Application No: BR/242/20/PL
Site Address: 51 Canada Grove Bognor Regis PO21 1DW
Description of works: Access ramp. This application affects the setting of a Listed Building, affects the character & appearance of the Bognor Regis Railway Station Conservation Area & is in CIL Zone 4 (Zero Rated) as other development.

Thank you for your internet representation made on 23rd November 2020 which has been recorded as no objection with the comments as follows:

No.	Description	Date
Client: Bognor Town Council		
Address: 51 Canada Grove, Bognor Regis, PO21 1DW		
Project: Disabled Access Ramp		
Drawing title: Block Plan		
Project No		SSE_194
Date		15-10-20
Drawn by		IA
Drawing No		BP01
Scale1:500@A3

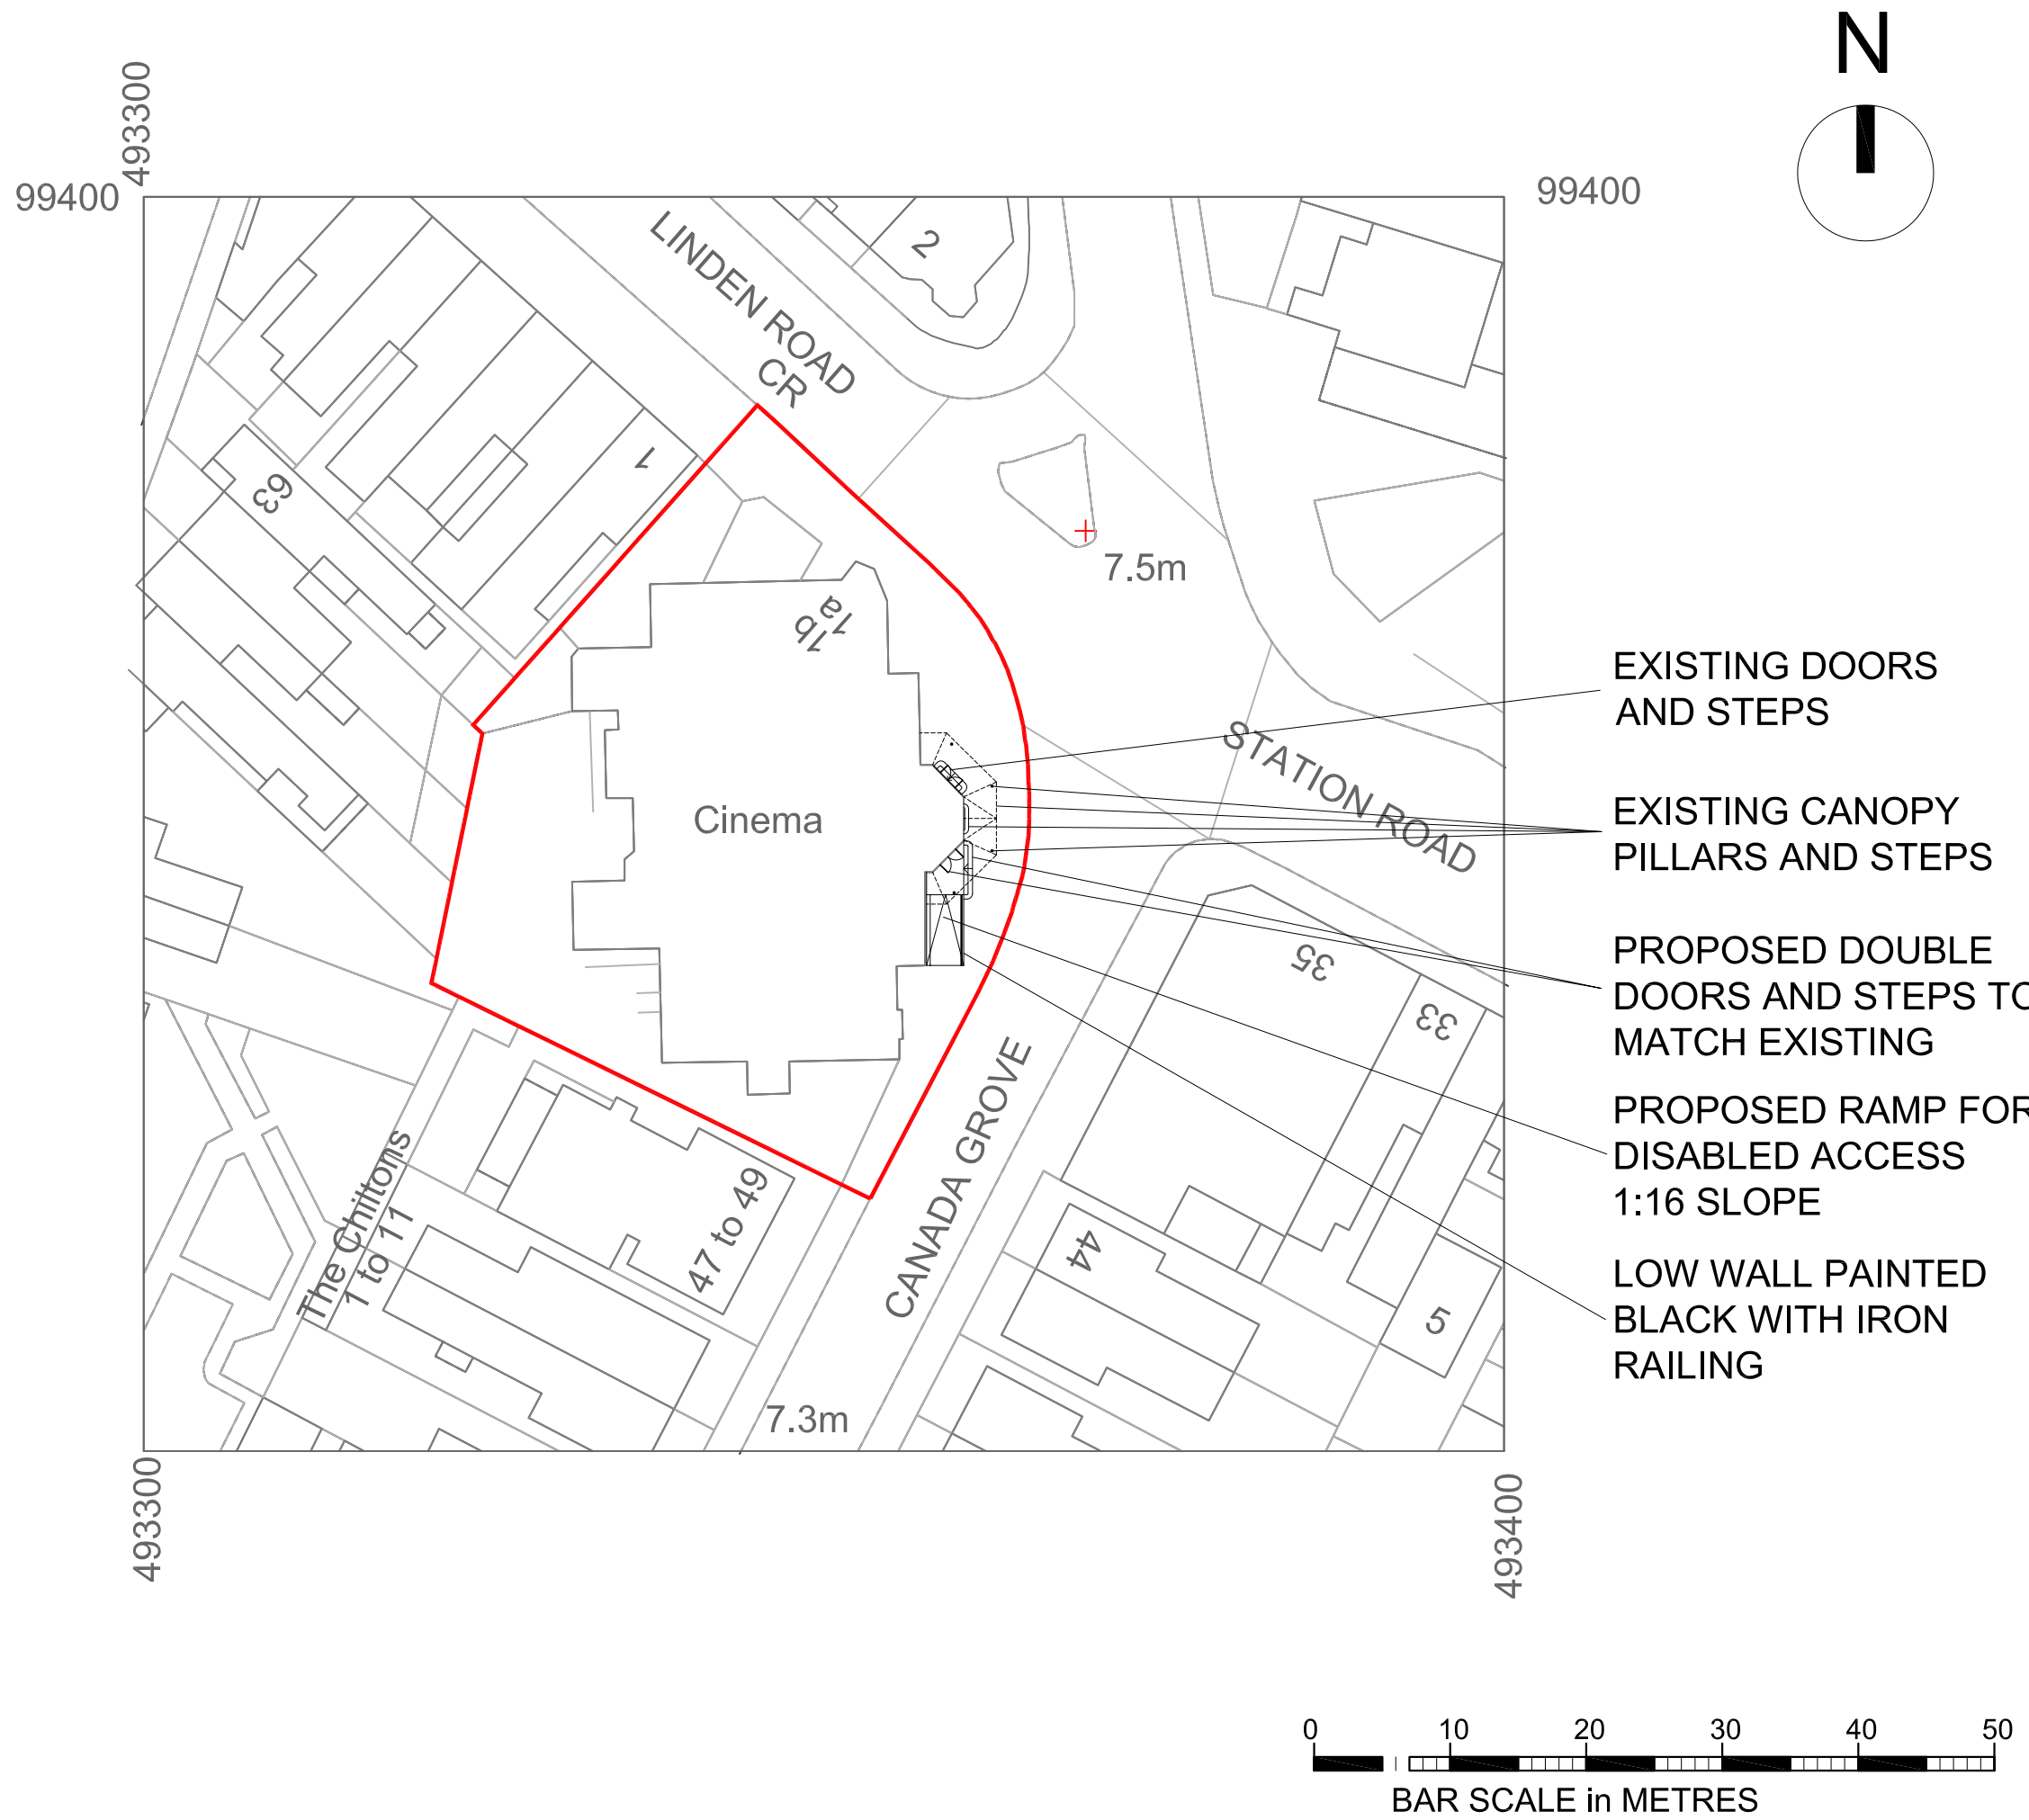
This is an important building in the area and as such the Panel regret the lack of a heritage statement or anything similar but believe that the work will have little effect on either the building or the area providing that the material for the handrail is of high quality and retains the style of wrought iron railings of the age of the building elsewhere in Bognor Regis.
